LOCAL HIGHWAY AUTHORITY CONSULTATION
To: Cherwell District Council

Planning Application No.	13/01584/F	Planning Officer	Andrew Lewis
Date	12th December 2013	OCC Officer	Judy Kelly

Location: Parcel B2A Camp Road Upper Heyford

Description: Erection of 69 dwellings with associated car parking, infrastructure and landscaping, provision of public open space, play areas and flood attenuation

Soft Landscape Proposals

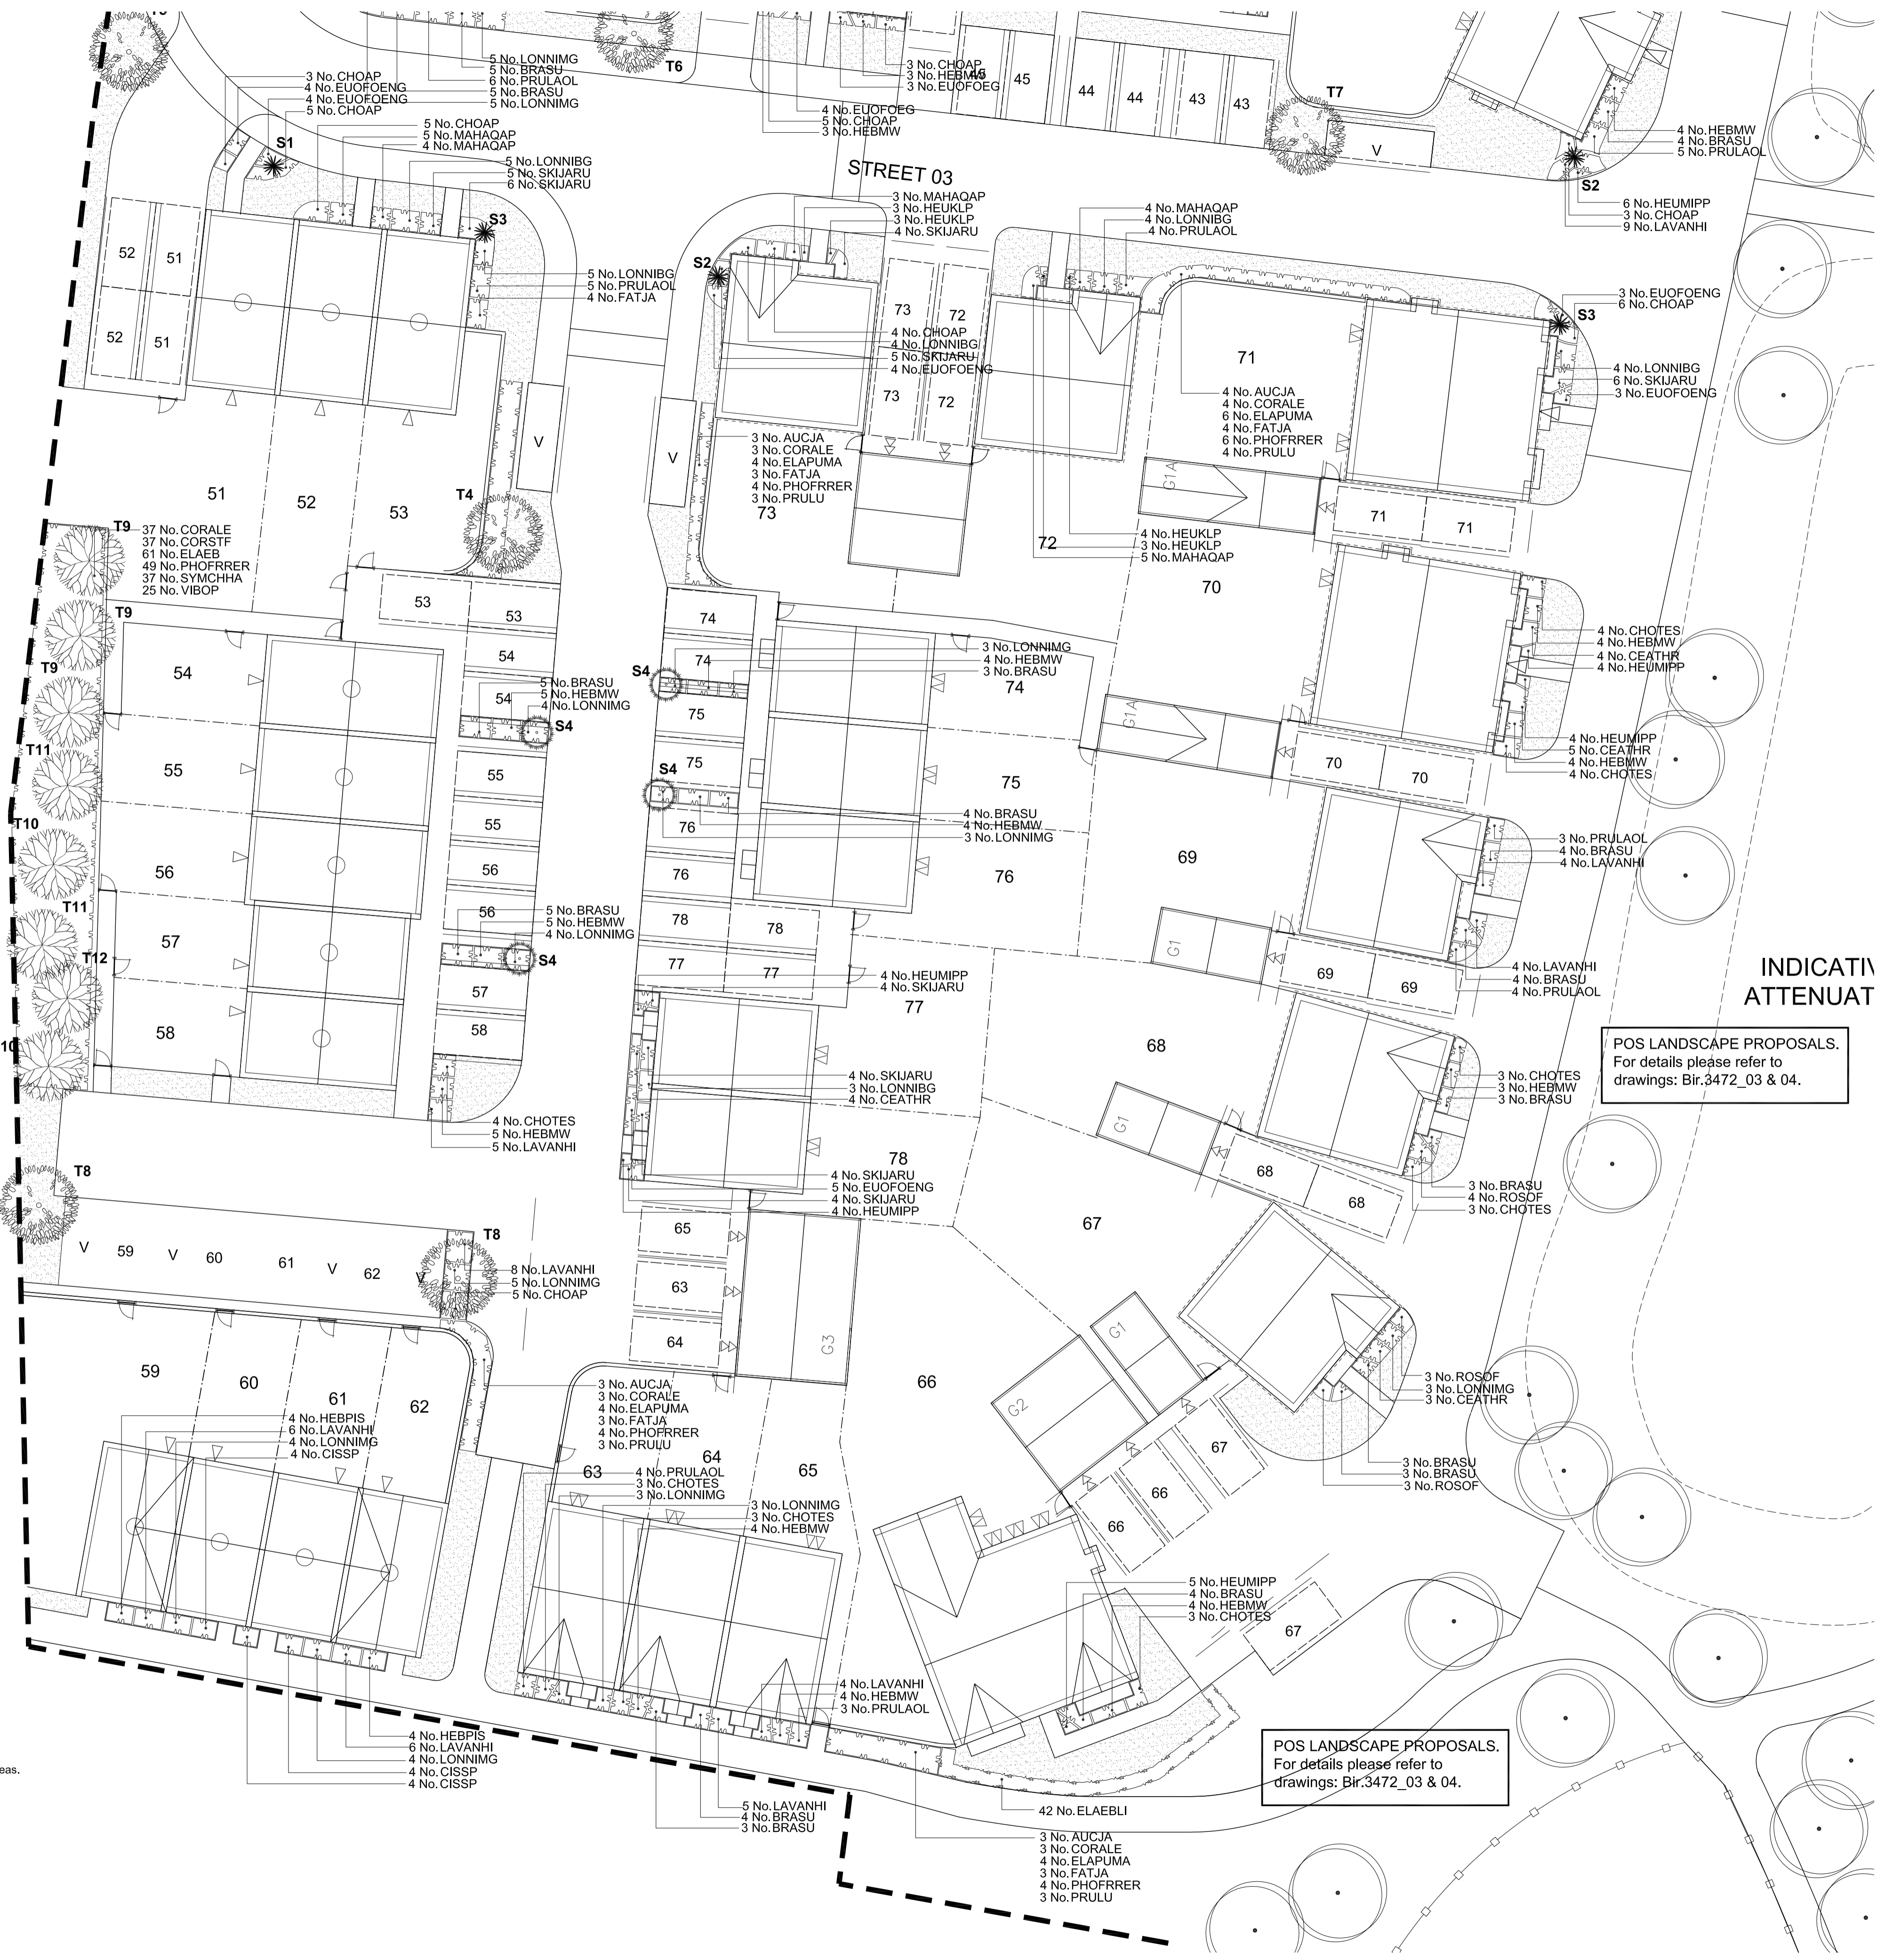
With regard to the planting along the southern side of Camp Road, either side of the new entrances, there may be some concerns for vision splays and would suggest that Darren Hemmings (Arboricultural Officer) is consulted as to the planting on this stretch, species and the future maintenance. Also these new entrances show what appear to be hedges along the edge of the cycle path. This also could cause visibility issues and in the current climate we would not wish to take on any vegetation that would need a lot of maintenance.

Hedges are outside of the proposed extend of S278 adoption, and will be adopted and maintained by an estate management company. Visibility splays

have been added to the drawings.
